From: Martyn White **On Behalf Of** Conservation Officer
Sent: 30 November 2018 10:03
To: Planning.Responses
Subject: BE/112/18/L

BE/112/18/L

The application is for Listed Building consent for alterations to toilet accommodation within the public house. Such a proposal will require some minor structural alterations to the building in order to improve the existing facilities.

Title
Plans as Proposed

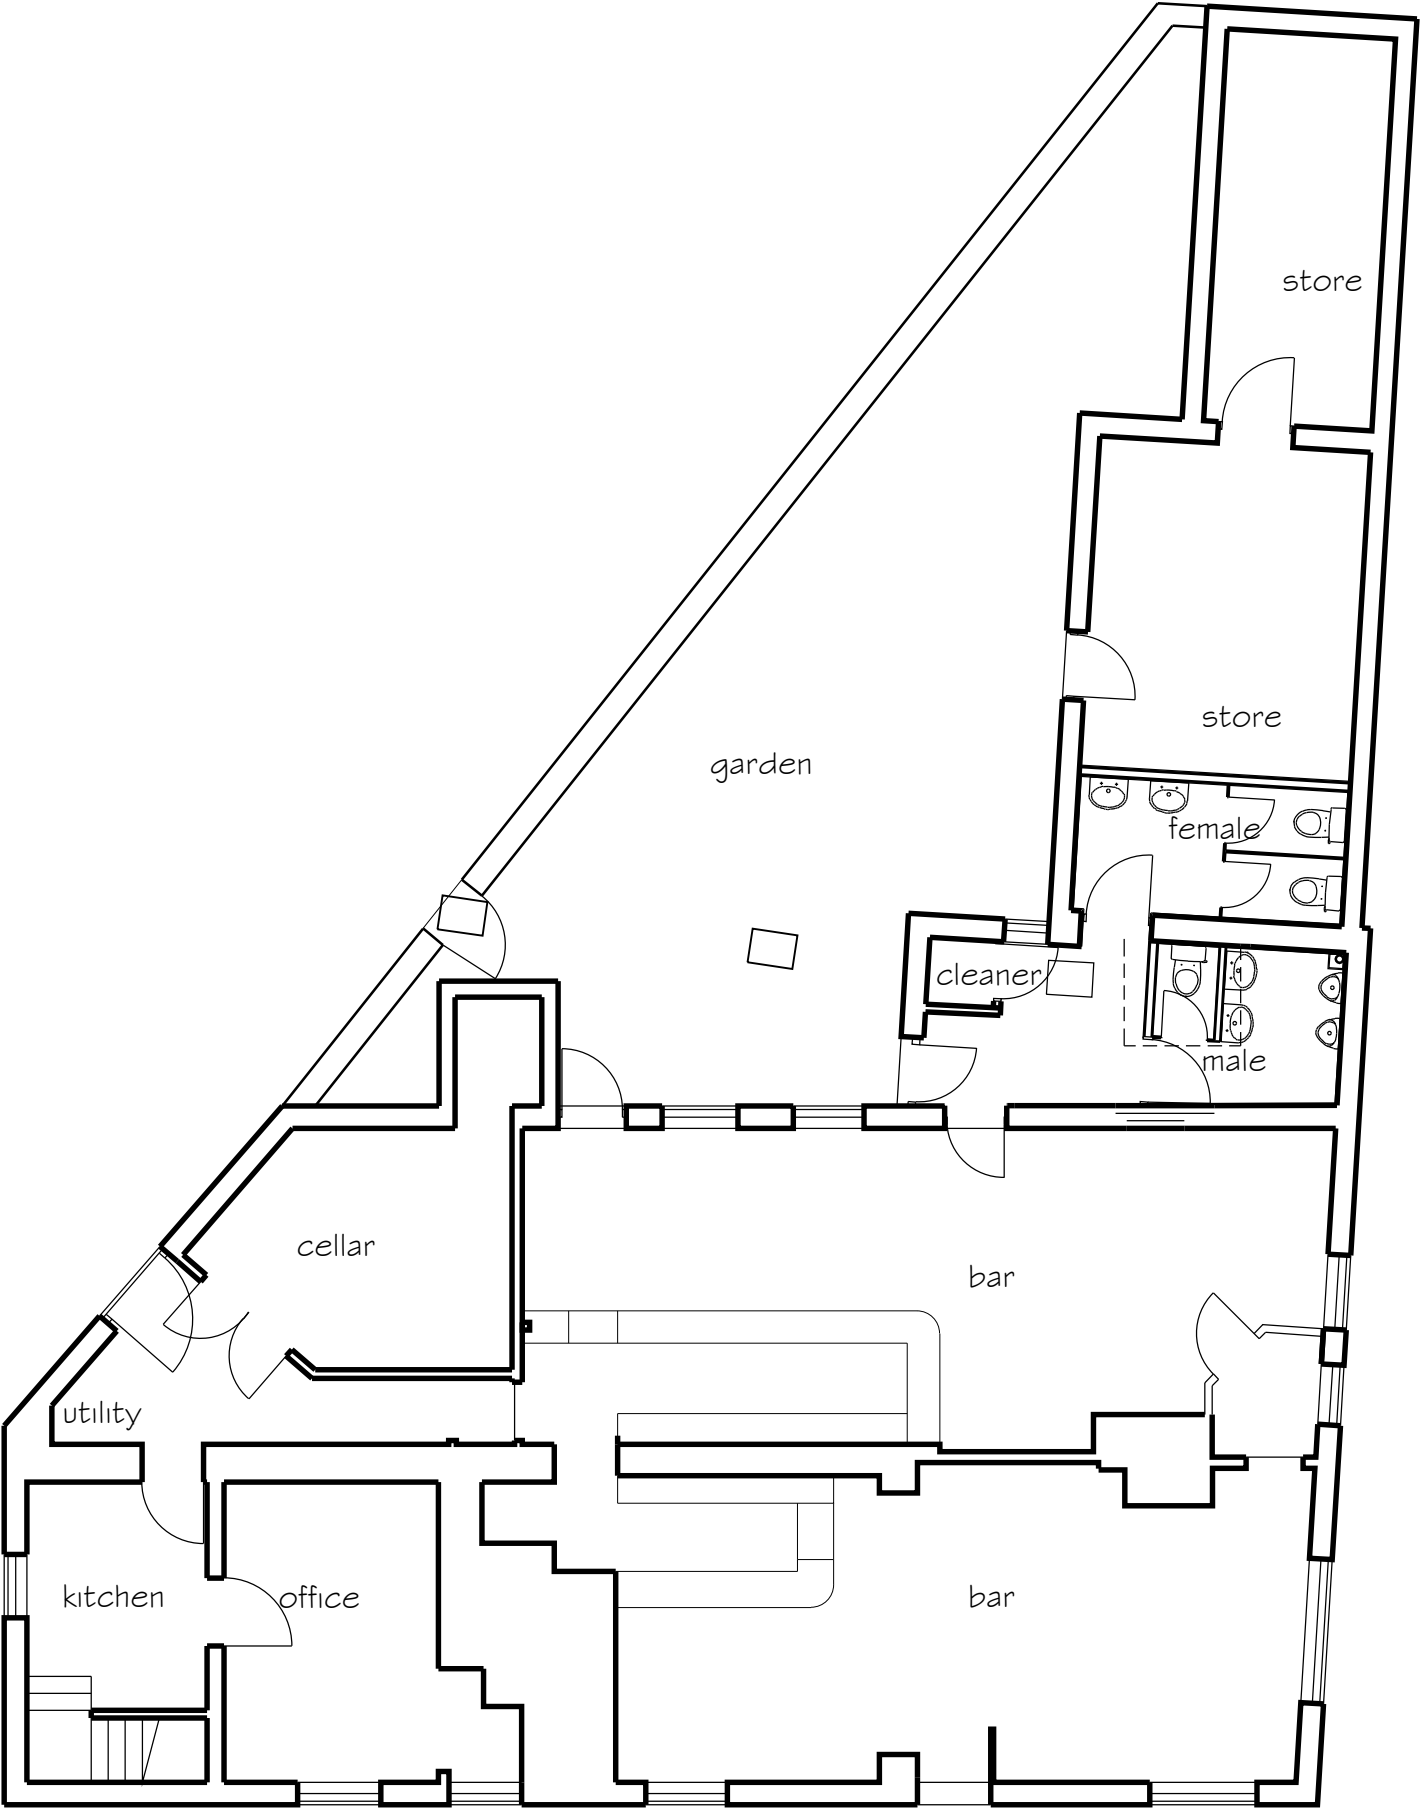
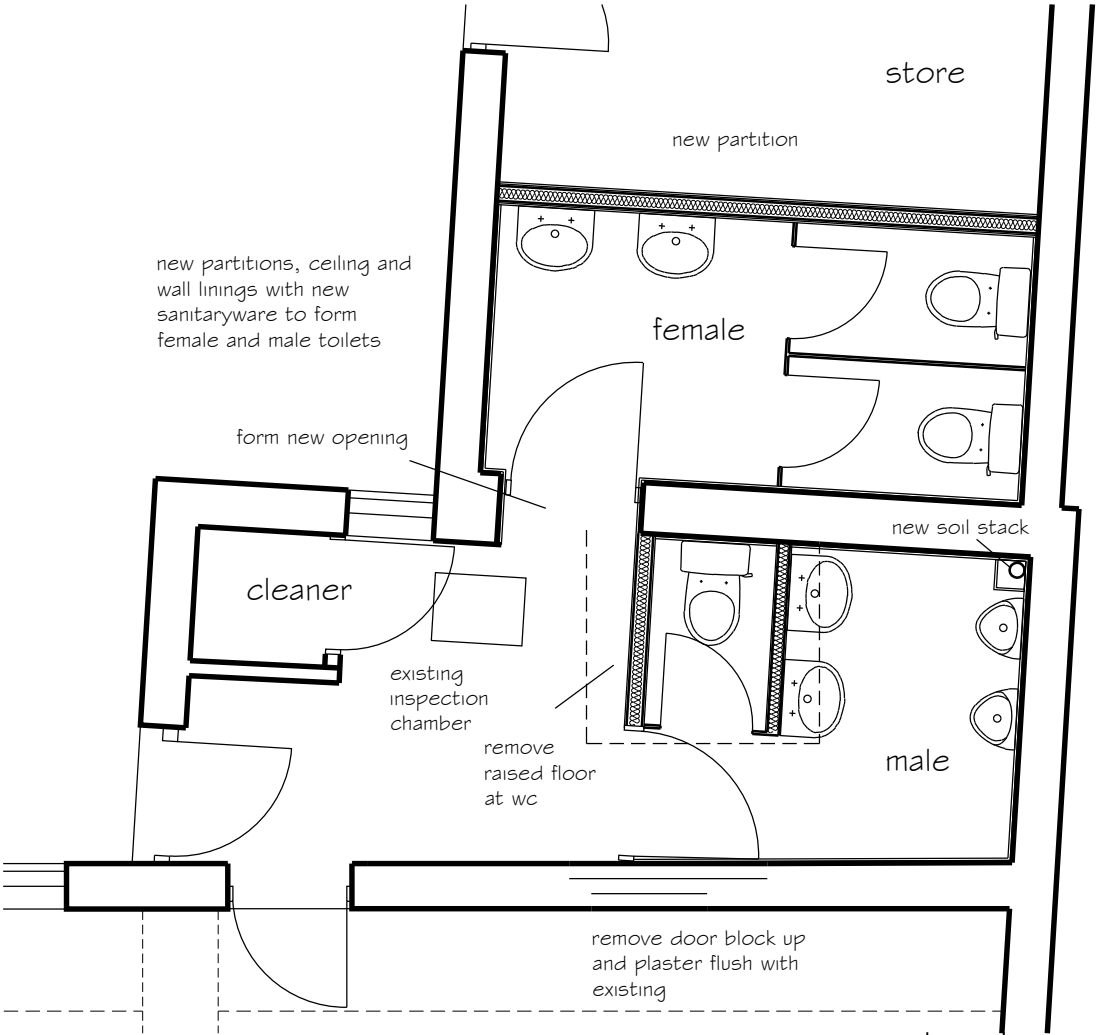
The proposal is considered to be acceptable, subject to the provision of additional details related to the proposed new internal doors.
